**RE: MACQUARIE UNIVERSITY ARTS PRECINCT PROJECT
BCA COMPLIANCE STATEMENT FOR SEC. 4.55 MODIFICATION SUBMISSION**

Reference is made to the Section 4.55 Application for the proposed modifications to the DA approved (SSD 8388) Macquarie University Arts Precinct development.

As instructed, we have undertaken a review of the proposed modifications as detailed on 'Section 96 Issue' architectural plans prepared by Architectus dated 4 July 2018. We note that the modifications relate to the centralization of the mechanical plant within the building.

PROPOSED FLOOR PLAN
LEVEL 8 & 9 25 WW B

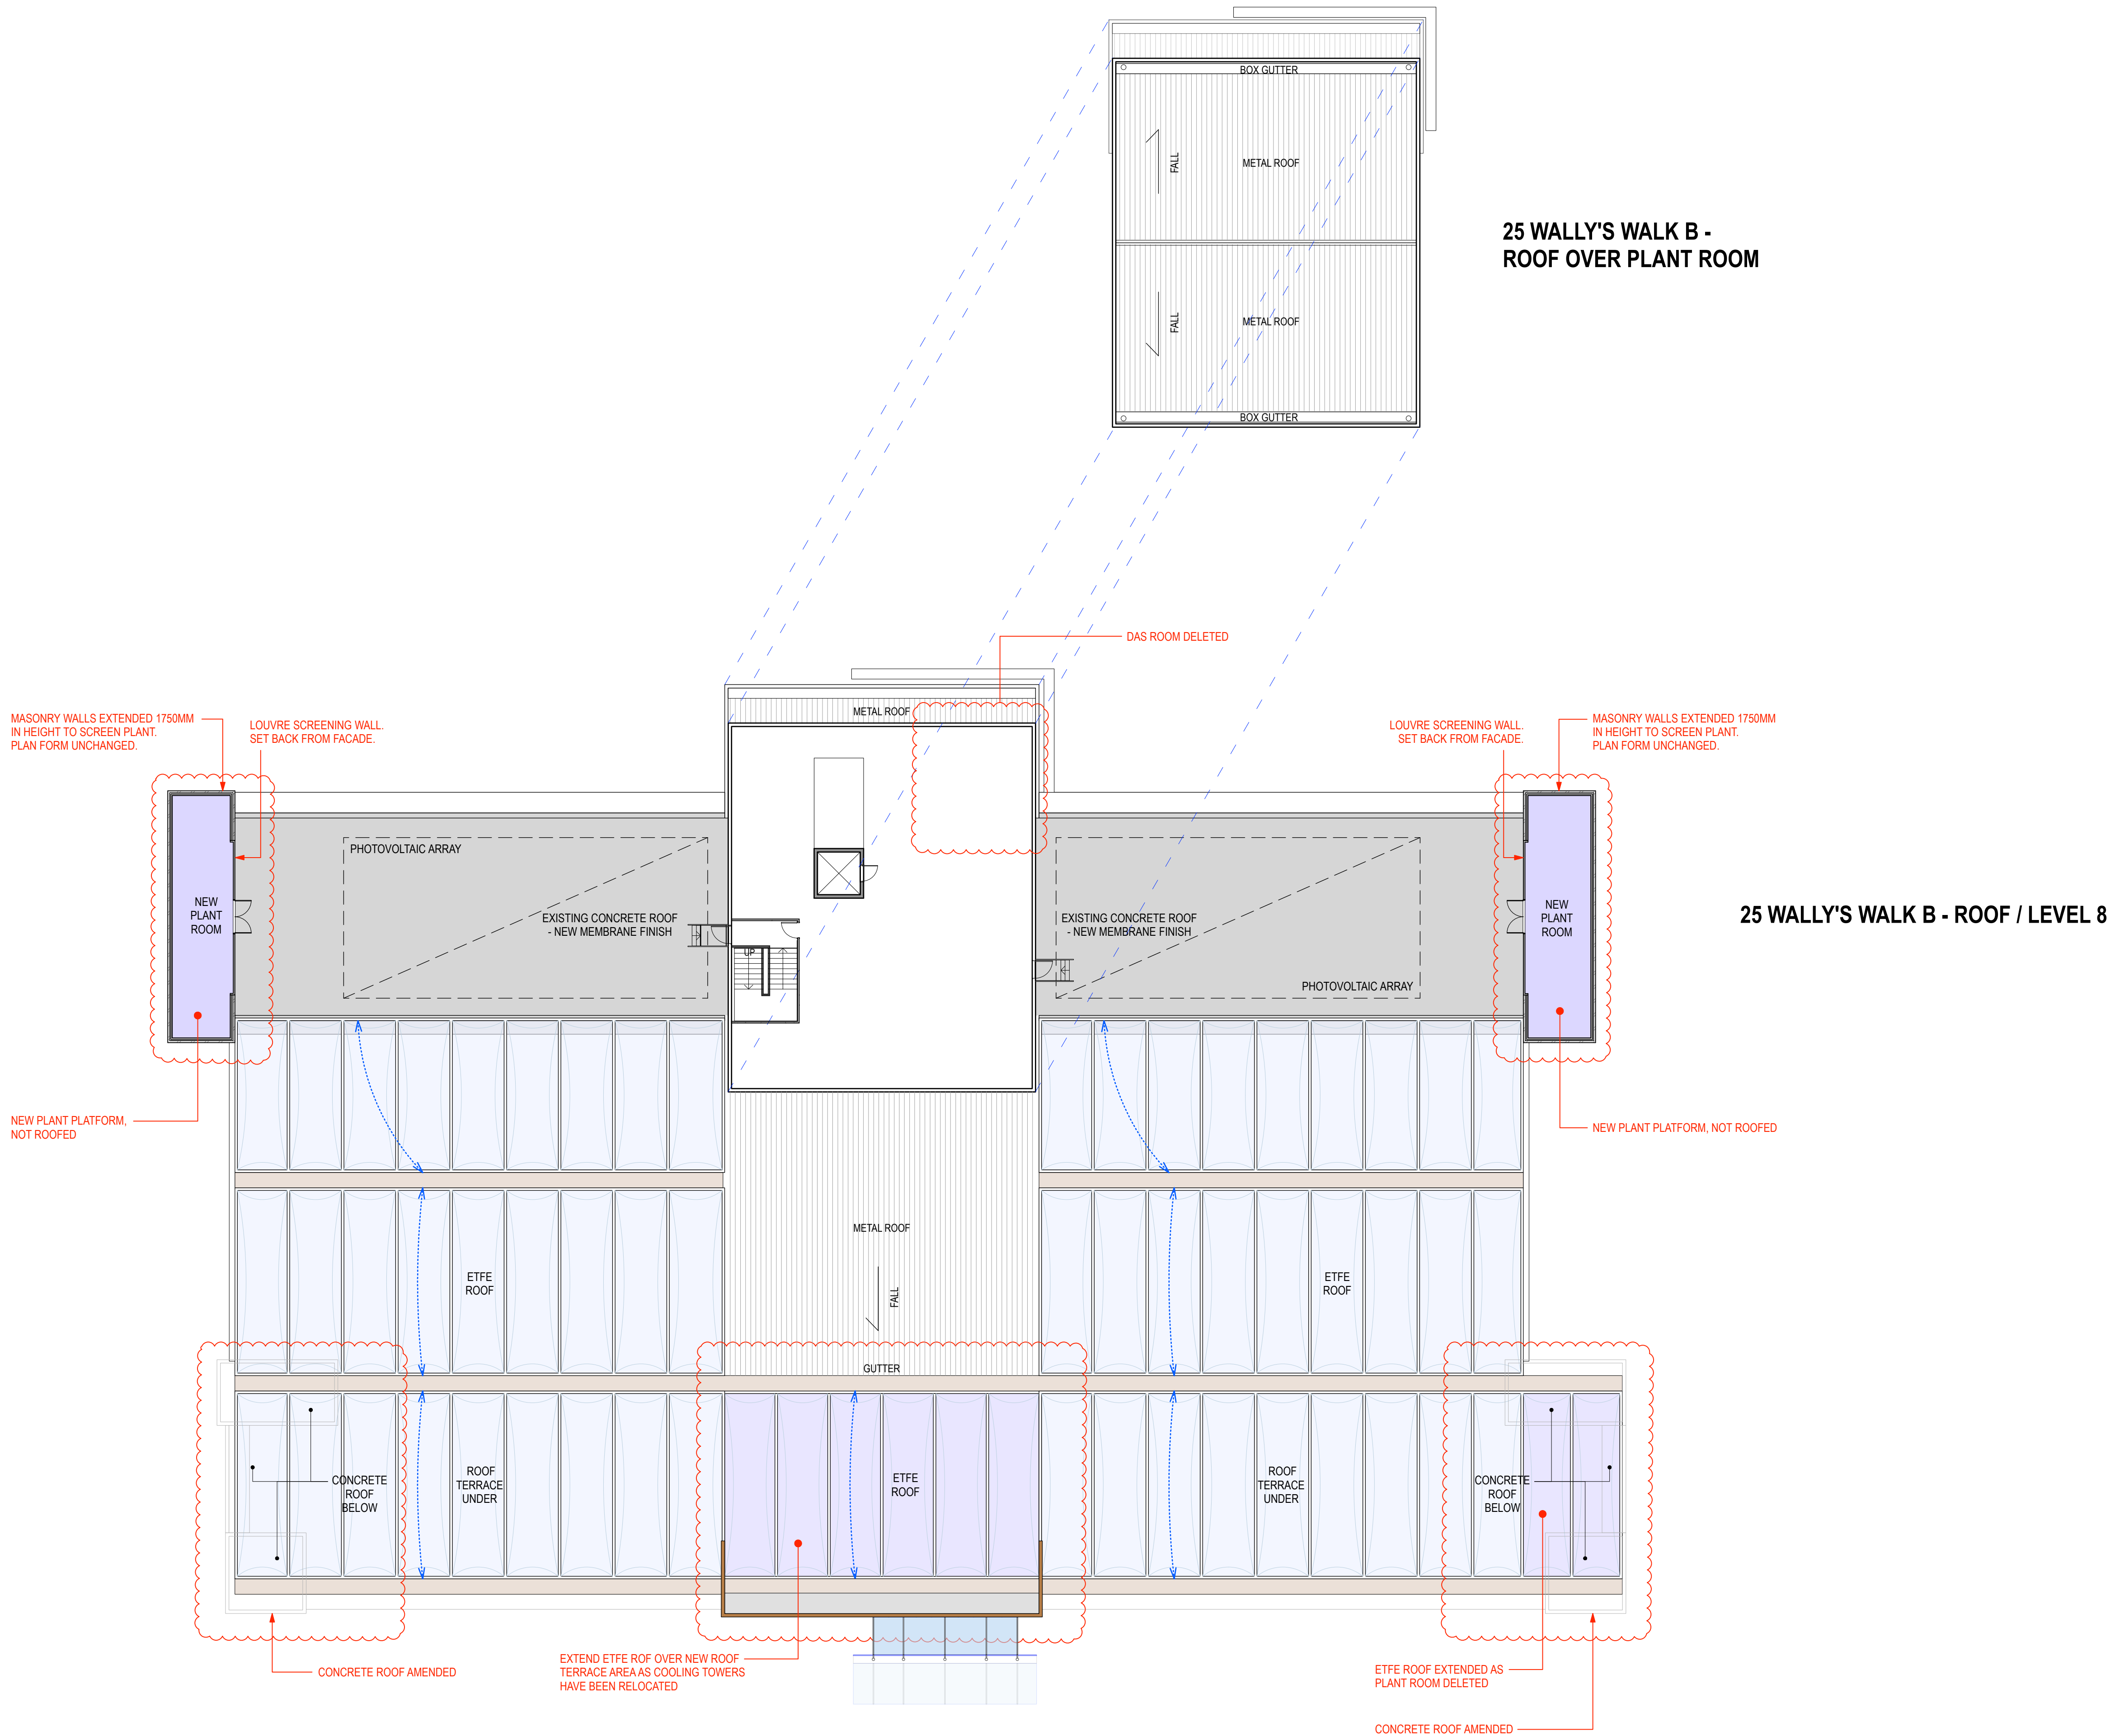
BCA CLAUSE/S		DESCRIPTION
1.	D1.4	To allow 55m to an exit from the roof plant area Building B (Level 8) in lieu of the BCA DTS maximum of 20m.
2.	D1.5	To allow 75m distance between alternative exits to the Roof Terrace (Level 4) of Building C in lieu of BCA DTS maximum of 60m.
